Your Ref: OWPC22055
Our Ref: M/24/19/PL 06-03-2019
Please ask for:
Andrew Wood

Replacement residential dwelling. This application may affect a Public Right of Way.
3 The Hard Elmer

PROPOSED FIRST FLOOR PLAN 1:50

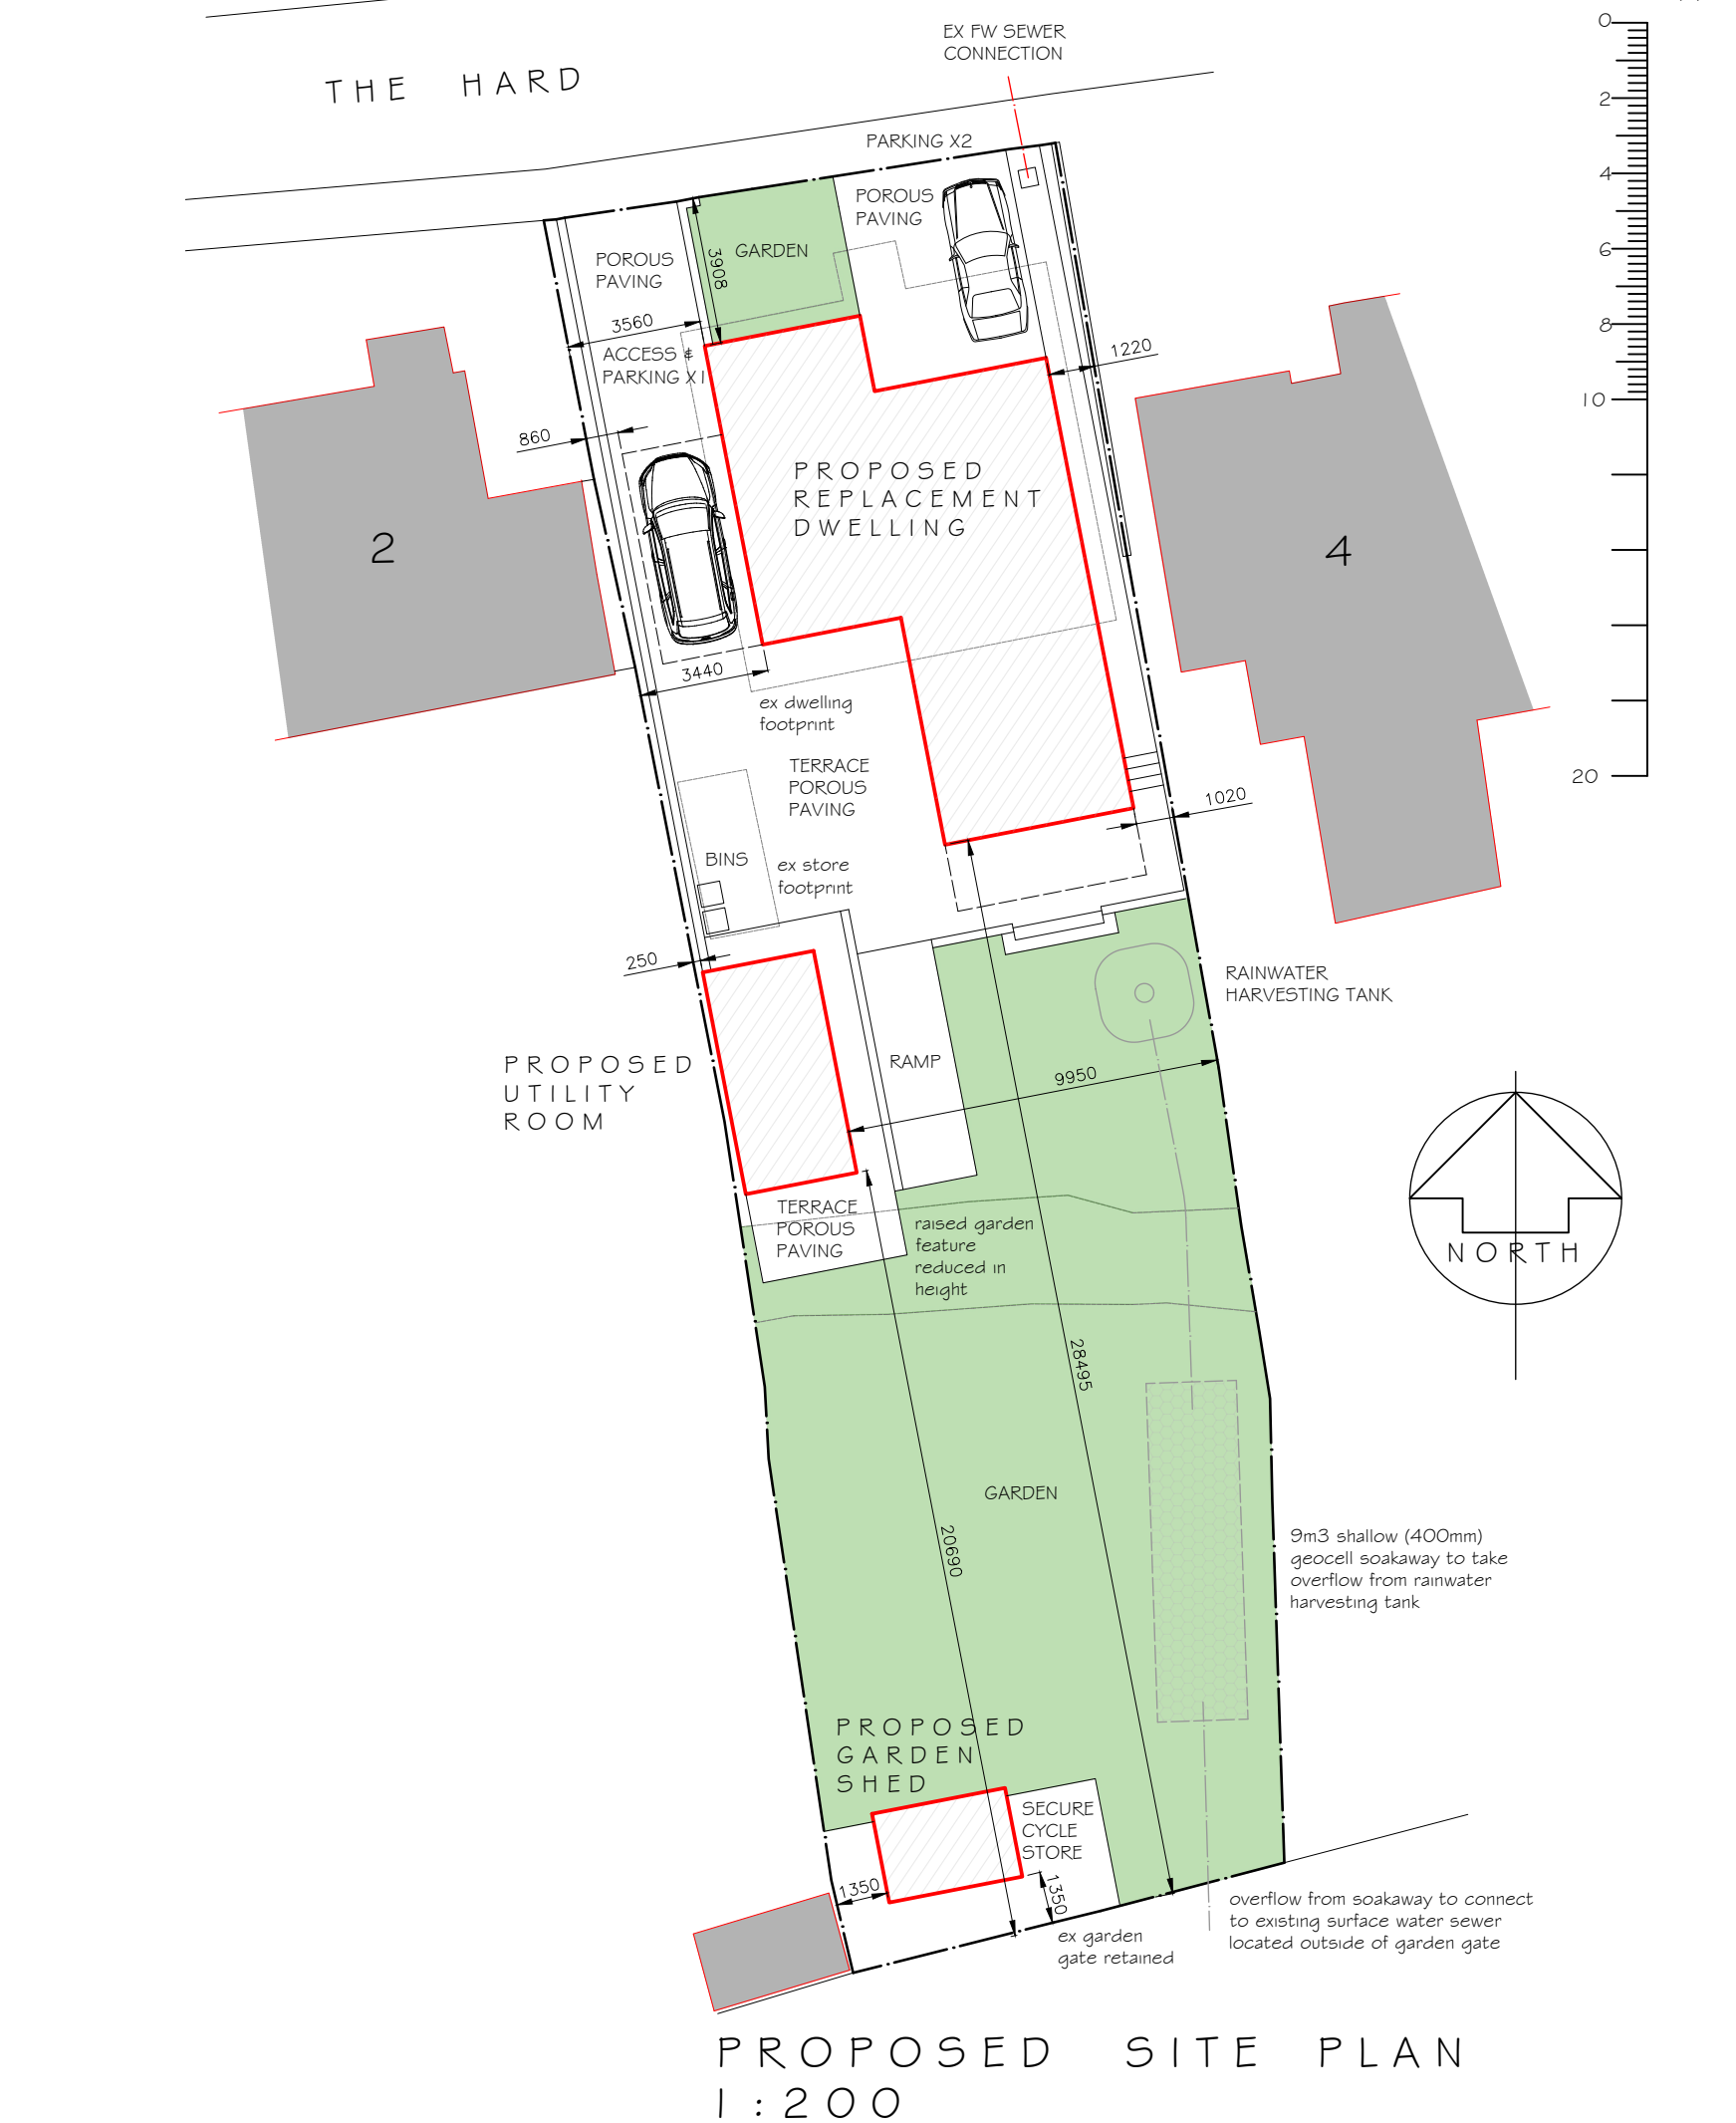
According to the plans, there is a reduction planned for "the garden feature". We would point out that this is NOT a garden feature but the original sea defence. This is continuous across several properties on The Hard. We are very concerned that reducing this sea defence will seriously compromise the effectiveness, especially with the Environment Agency's concerns regarding rising sea levels and constant warnings of more and stronger storms in the future due to global warming. We trust you will consider the implications this action may cause.
